From: Brian Elstone [REDACTED]
Sent: 03 February 2022 16:32
To: Anita Gardner <Anita.Gardner@arun.gov.uk>
Subject: RE: LU/383/21/PL Garage Extension 9 North Street, Littlehampton

Subject: LU/383/21/PL Garage Extension 9 North Street, Littlehampton

Revision	Date	Description
Client: The Car Surgery, 9 North Street, Littlehampton, BN17 6JJ		
Project: Extension to Rear		
Drawing Title: Proposed Ground Floor		
Scale:	Date:	Drawn By:
1:100	17/06/2021	BE
Drawing Number:	Revision:	
1410/003	-

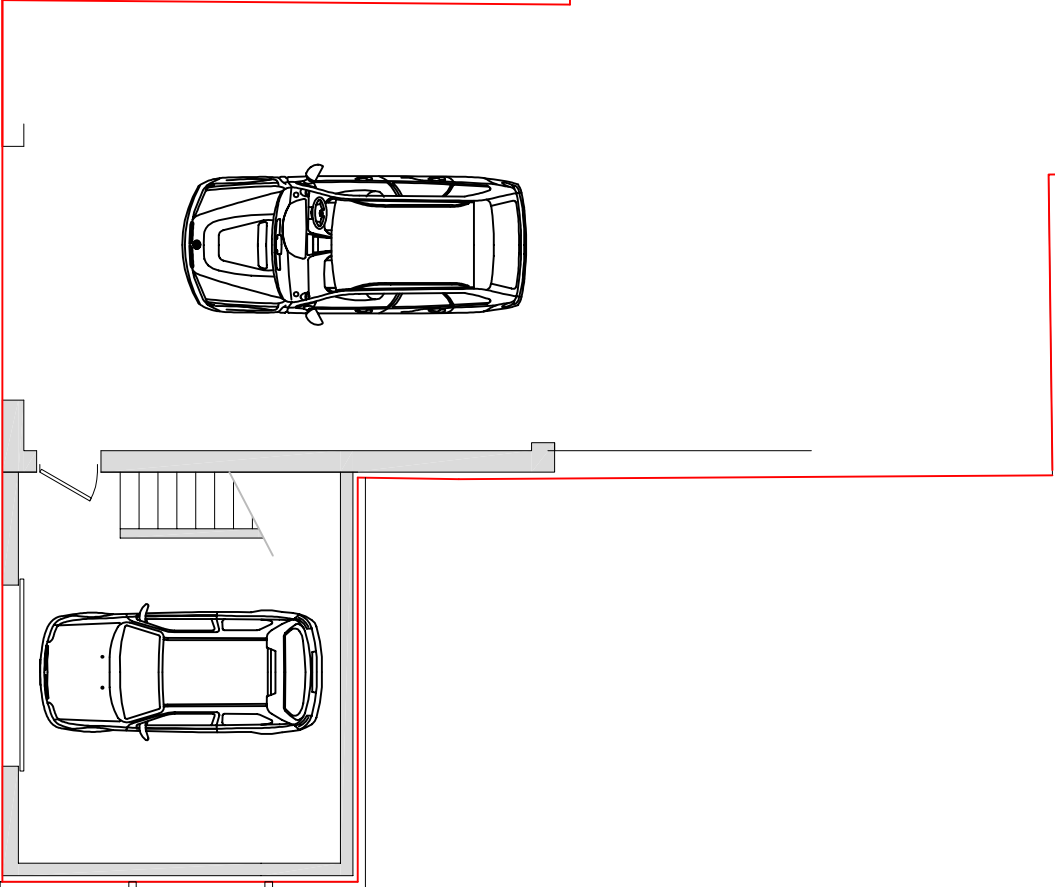
I need to address the comments made by the Town Council in my report and the detail submitted with the application is limited. Please can you advise whether the extension reduces the availability of existing car parking within the site and if so by how many spaces? Can you confirm the existing and proposed car and cycle parking? What is the purpose of the extension. Is it to improve existing facilities or expand them, in other words, are the number of vehicles/customers visiting the site per day likely to increase as a result of the extension?

I note that the application form states there would be no additional staff employed. Can you advise what staff facilities are available at the site. The ground floor plan only provides an extract.

There is no parking for customers on site, usually customer's cars are driven into service bays by staff by appointment, the new facility will be for customers who previously had to park in the street and walk to "The Car

Surgery" and leave their keys, when the garage staff would then go and collect the cars from the street. This new facility will save one space in the street.

The existing facility already has adequate welfare facilities for staff, this will not change with the new extension.

The area being developed is at present unused as part of the business.

The new extension will give additional servicing facilities and clear away equipment in the existing garage area but will not change the scope of the business. It will enable engineers to work on a vehicle under cover.
